Our Case Number: ABP-310286-21

Re: Railway works and all works necessary to eliminate and, where necessary, upgrade seven numbered level crossings and carry out all associated and ancillary works along a 24-kilometre section of the Dublin to Cork Railway Line.
Fantstown, Thomastown, Ballyhay, Newtown, Ballycoskery (Ballyhea Village), Shinanagh and Buttevant, Co. Cork and Co. Limerick.

Board of Management Ballyhea National School
Submission to An Bord Pleanála
Case no. NA04.310286
Ballycosgery (Ballyhea Village) Level Crossing 212

Figure 2.11: XC212 Ballycoskery Proposed Alignment

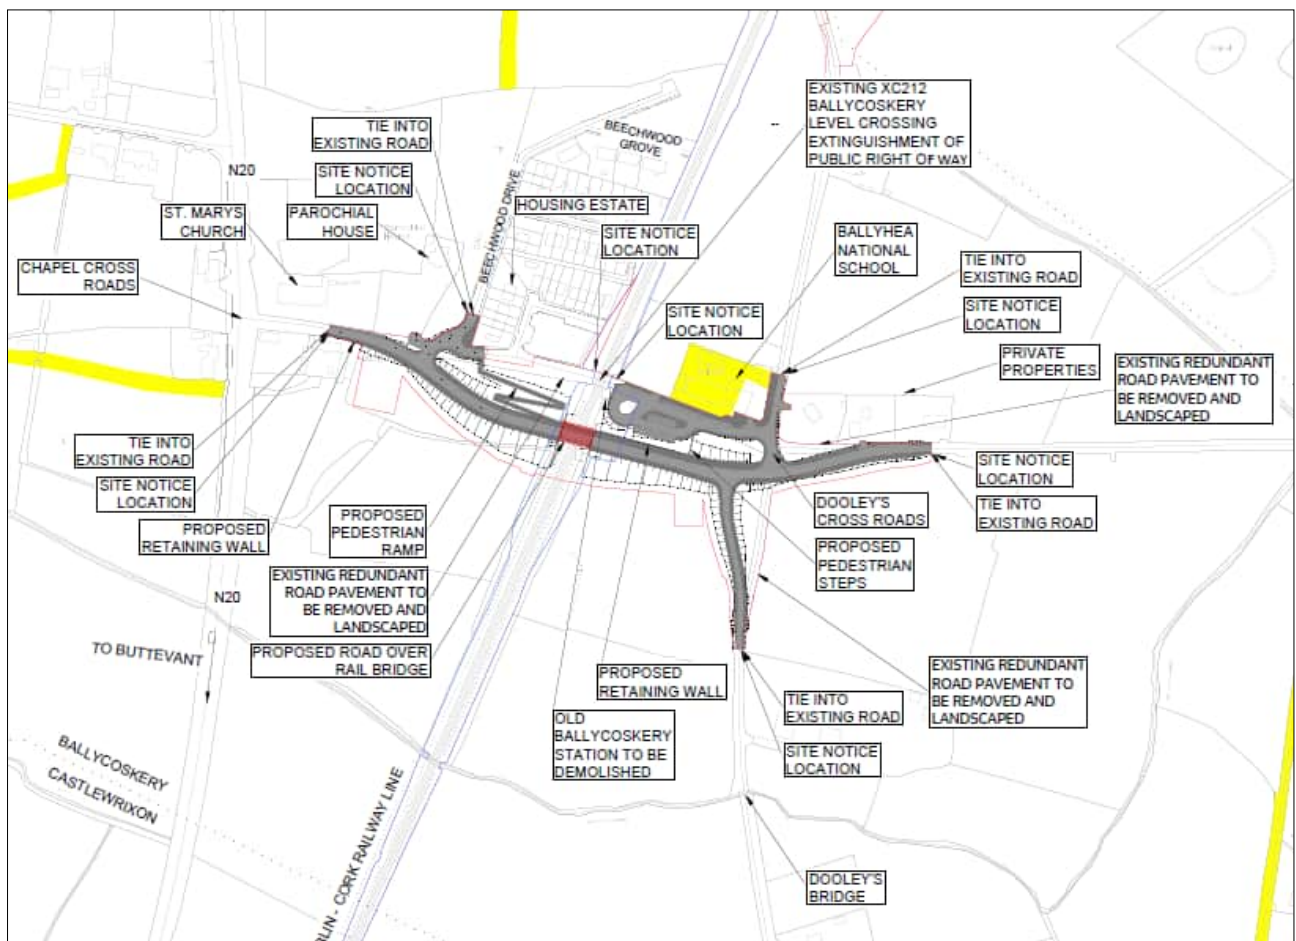
The development, as proposed, significantly reduces the current ease of direct and safe interconnectivity between western part of the village, including the church, parochial house, bus stop, public car park, and the eastern part of the village including the school and community hall. It significantly reduces ease of direct and safe pedestrian access between the eastern part of the village including the school and the community hall and the western part of the village. The development, as proposed, tends to render the school isolated from the western part of the village.

The BOM notes the effects of elimination of the present easy, direct and safe pedestrian and vehicular access to the school from the western part of the village, and specifically from the N20. This route is used by parents going to work to convey their children to the school from the more populated area to the west of the railway line. A foreseeable consequence of the proposed development at XC212 is to render it more convenient for parents going to work to drop their children off at schools with immediate access to the N20 in Buttevant and Charleville - with the resultant negative impact on Ballyhea school's catchment area. Any negative impact on the numbers of children attending the school will ultimately affect its long-term viability.

A similar road-over-rail development with accompanying car par for the school was proposed to Cork County Council by CIE in 2011. A summary of the events leading to its rejection by the Council is contained in the *Planning Compliance Report*,(p. 83 and appendix H, pp. 86/89). The issues raised concerning the proximity of the development to the school were never resolved. They remain unresolved.

Figure 4-9 XC212 Alternative options

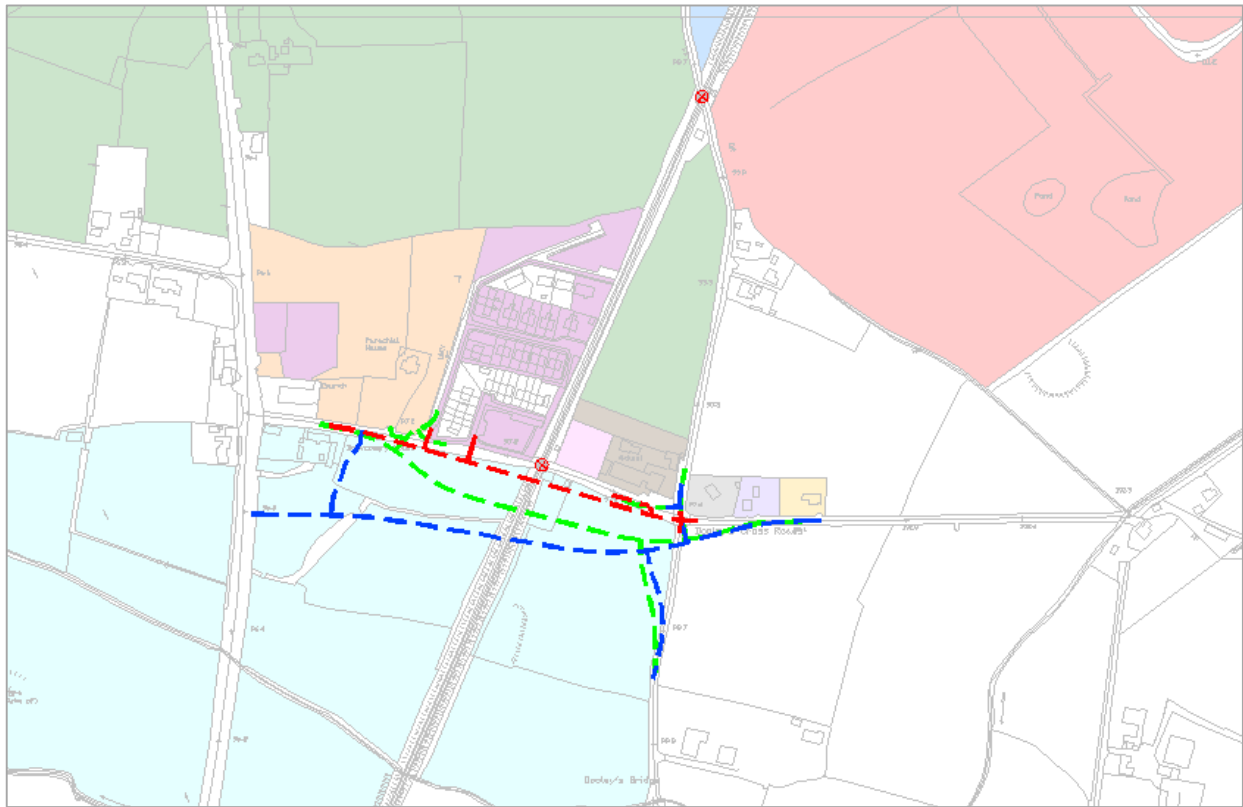
The proposed road-over-rail solution at Ballycosgery was selected by CIE as the preferred of three options: two road-over-rail solutions and one rail-over-road option. The documentation submitted to ABP affords an abbreviated history of the project and an account of the methodology used by CIE in its application of the *Department of Transport, Tourism and Sports' publication Guidelines on a Common Appraisal Framework for Transport Projects and Programmes*, particularly in *Cork Line Level Crossings Volume 2, ELAR Introductory Chapters*, section 2.3.3, p. 21. The BOM notes that the guidelines indicate the criteria for a qualitative assessment of a

project as: Economy• Safety• Environment• Accessibility and Social Inclusion• Integration• Other Government Policies• and Non-quantifiable economic impacts. (*Guidelines on a Common Appraisal Framework for Transport Projects* (2020 edition), pp. 41-49). The BOM notes that the MCA study conducted by CIE in an effort to identify a preferred option was an abbreviated study that omitted a number of the guidelines' criteria. No reasons were specified for those omissions. They were merely declared to be not relevant or not considered part of a Route Options Report (CLL, vol. 2, pp.21/22). Thus, the criteria for CIE's restricted MCA are: Economy, Engineering, and Environment (*ibid.*, p. 22, table 2.7). Other criteria, such as • Accessibility & Social Inclusion; • Integration; and, • Physical Activity were excluded from the analysis because "*As such, it was assumed that there is no relevant differentiation between the route options regarding... [those] criteria*" (*ibid.*, p. 22), [emphasis added]. This curtailment of criteria eliminated consideration of several factors which have effects on the differentiation of route options at Ballyhea. For example, Accessibility and Social Inclusion criteria cover groups such as "...those suffering from social deprivation, geographic isolation and mobility and sensory deprivation" (*Guidelines on a Common Appraisal Framework for Transport Projects* (2020 edition), p. 38). Other examples can be found. Clearly, such groups are relevant to an MCA study and do have a differentiating effect on route options – and on the three options proposed for Ballycosgery. The BOM maintains that the restricted MCA study conducted by CIE is inherently flawed particularly in its application to an area of defined settlement, i.e. Ballyhea village. A more comprehensive application of MCA criteria would have significantly affected the differentiation process without necessarily confirming the present road-over-rail solution and quite possibly by further enhancing the rail-over-road option, that already has several environmental strengths and for which a positive consensus exists among the affected landowners and those more immediately impacted by the proposed Ballycosgery development.
